DOC18/662068-1
DA 231-07-2000

Dartbrook Coal Mine Modification 7 (DA 231-07-2000) - Response to Submissions

Dartbrook Coal Mine – Modification 7 (DA 231-07-2000) – Response to Submissions

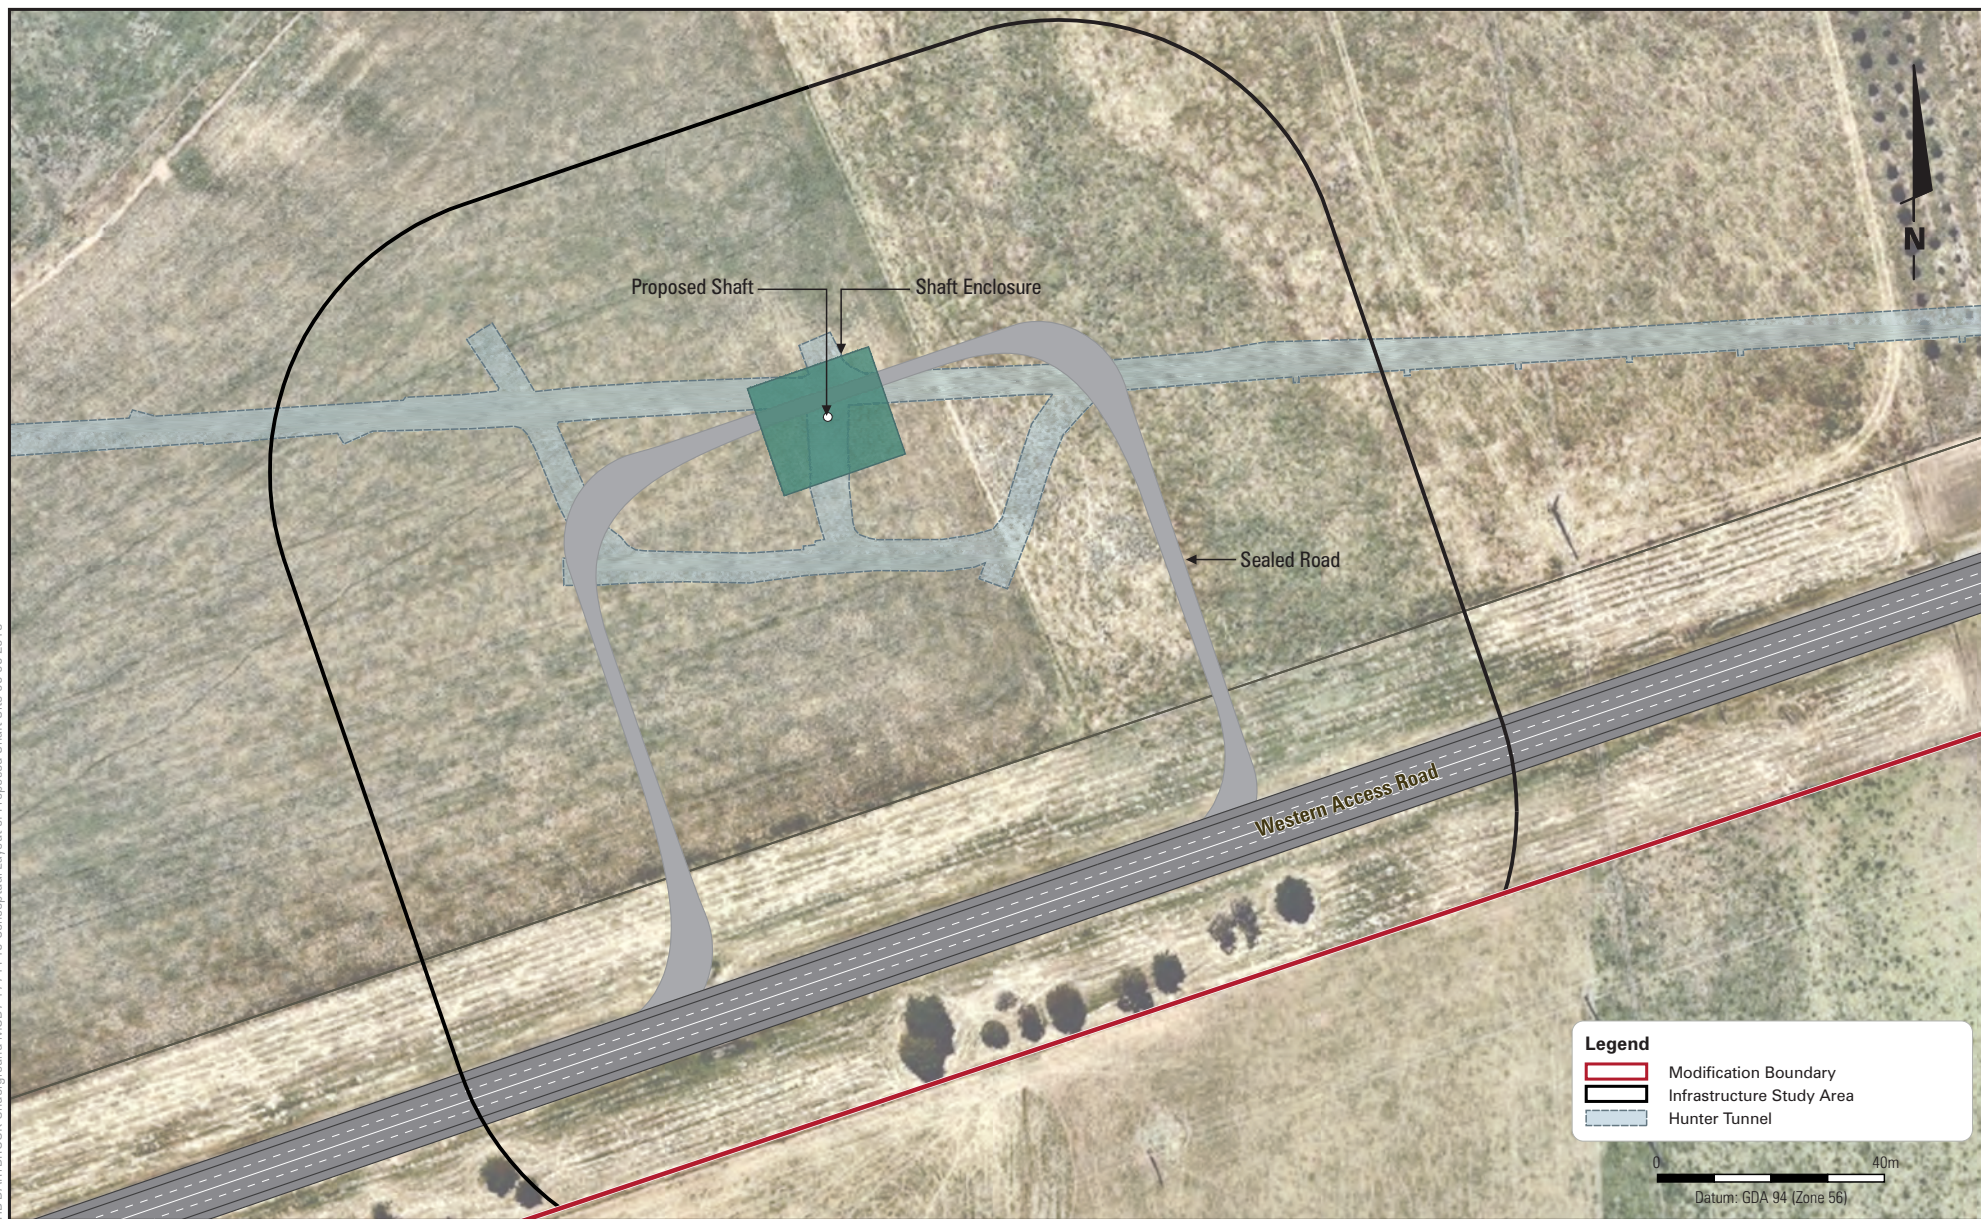
Section 2.12.4 of the Response to Submissions (RTS) report refers to the Aberdeen Flood Study, WMAWater (2013) and flood depths of less than 400 millimetres in the 1% Annual Exceedance Probability (AEP) flood event at the proposed shaft site. The depth of flooding in the Probable Maximum Flood (PMF) event is not provided, although the proposed shaft site is within the PMF flood extent.

Insufficient detail has been provided regarding the risk to personnel on the site as a result of flooding at the proposed shaft site. The depth, velocity or rate of rise of floods greater than the 1% AEP flood event have not been considered in the RTS report, and these could pose a high flood risk to personnel as a result of entry of floodwaters into the shaft. Floods greater than the 1% AEP have occurred several times in the past couple of years within the Hunter Valley area.

Flood mapping in the Aberdeen Flood Study (Figure 28, Aberdeen Flood Study, (WMAwater, 2013) indicates that the PMF will have flood depths in excess of 5 metres in the vicinity of the shaft location. Flood depth in excess of the height of any proposed protection works and/or failure of protection works would result in floodwater entering the shaft and the connected Hunter Tunnel and poses a significant risk to life and infrastructure. Relocation of the shaft out of the floodplain would remove any flood risk to the shaft; this option has not been considered in documentation provided for review.

Section 2.12.4 of the RTS report refers to the Aberdeen Flood Study (WMAWater, 2013) and flood depths of less than 400 millimetres in the 1% Annual Exceedance Probability (AEP) flood event at the proposed shaft site. The possibility of constructing an earthen mound or a levee to protect the proposed shaft during the 1% AEP flood is included in the RTS.

However, there is no indication of the depth of flooding in floods greater than the 1% AEP flood event, and what infrastructure would be required to protect the shaft entry point in floods greater than the 1% AEP event. Flood planning levels are generally a minimum of 500 millimetres above the 1% AEP flood event level in recognition of the uncertainty of the flood modelling process, allowances for some climate change and wind or wave impacts. Protection works built to the 1% AEP flood event level, or greater, are likely to be inadequate to prevent entry of flood waters into the shaft.

Insufficient detail has been considered regarding the risk to infrastructure as a result of flooding at the proposed shaft site. Relocation of the shaft out of the floodplain would remove any flood risk to the shaft, but this option is not discussed in the documents provided for review. The RTS lists two potential options to manage this flood risk: a levee, or an earthen bund. However, OEH has concerns that neither of these would be technically feasible, given the constraints and structural requirements to manage vehicular loads.

The risk to life from the PMF flood or floods larger than the 1% AEP flood event cannot be adequately managed by emergency procedures. It is recommended that the shaft be relocated outside of the PMF extent.

The risk of floodwaters entering the shaft and Hunter Tunnel has not been adequately addressed. The risk of floodwaters entering the shaft and Hunter Tunnel cannot be adequately

managed by construction of a low levee or bund. It is recommended that the shaft is relocated outside of the PMF extent or alternate methods of coal transfer be devised.
